Rezoning Transportation Analysis

Petition Number: 2023-013

Date	Description
05-24-2023	First Review (PDM)

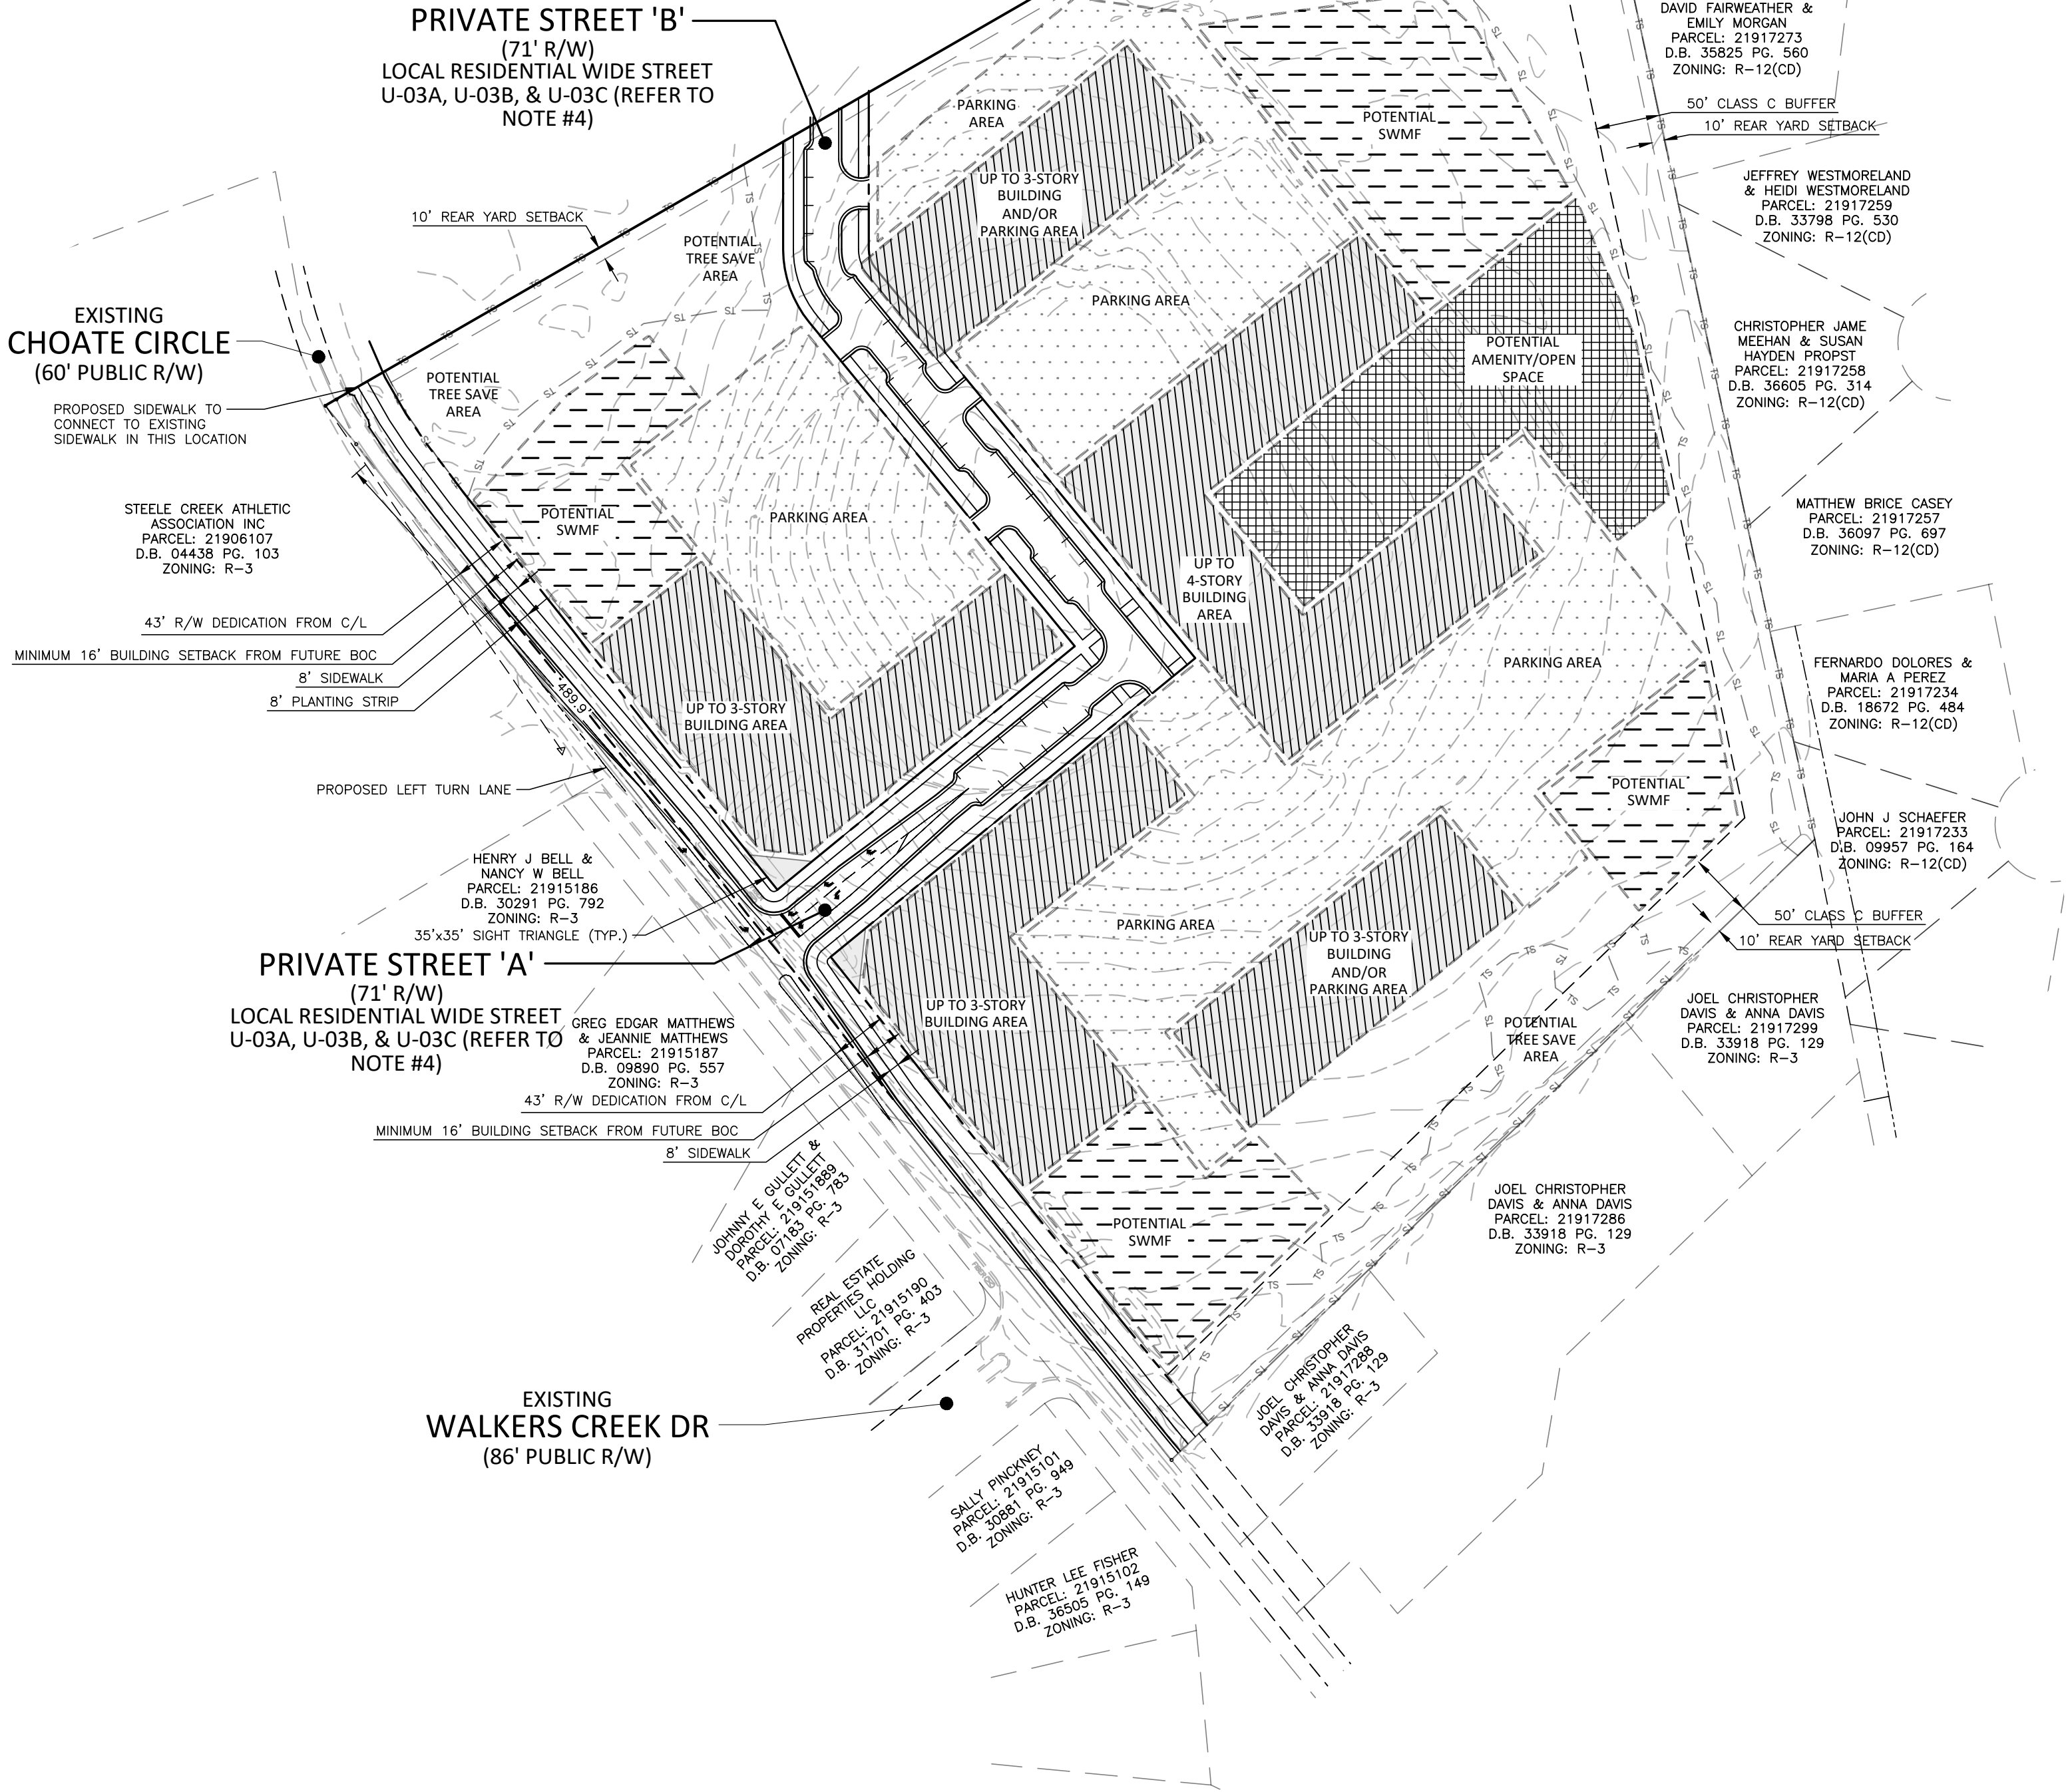
Choate Circle: Location of curb and gutter to be installed a minimum of 19 feet from roadway centerline to accommodate the Charlotte Streets Map with a roadway typical section of a 2+ Avenue.

Label and dimension the curb and gutter from the centerline for each road on the site plan.

4. Revise site plan and conditional note(s) to commit to dedicate a minimum of 35 feet of right-of-way from the road centerline on Choate Circle. The site plan shall label and dimension the right-of-way from the road centerline. Provide SUE for multi-use path if located outside of the ROW.
5. Revise site plan and conditional notes(s) to convert the proposed private streets to public streets.
6. Revise site plan and conditional note(s) to commit to construct bicycle facilities installing a 12' multi-use path and 8' planting strip to meet the Council-adopted Charlotte BIKES Policy. Multi-use paths maintained by the City shall meet ADA/PROWAG requirements.
7. Revisit site plan to remove the left turn lane stop bar shown on Choate Circle.
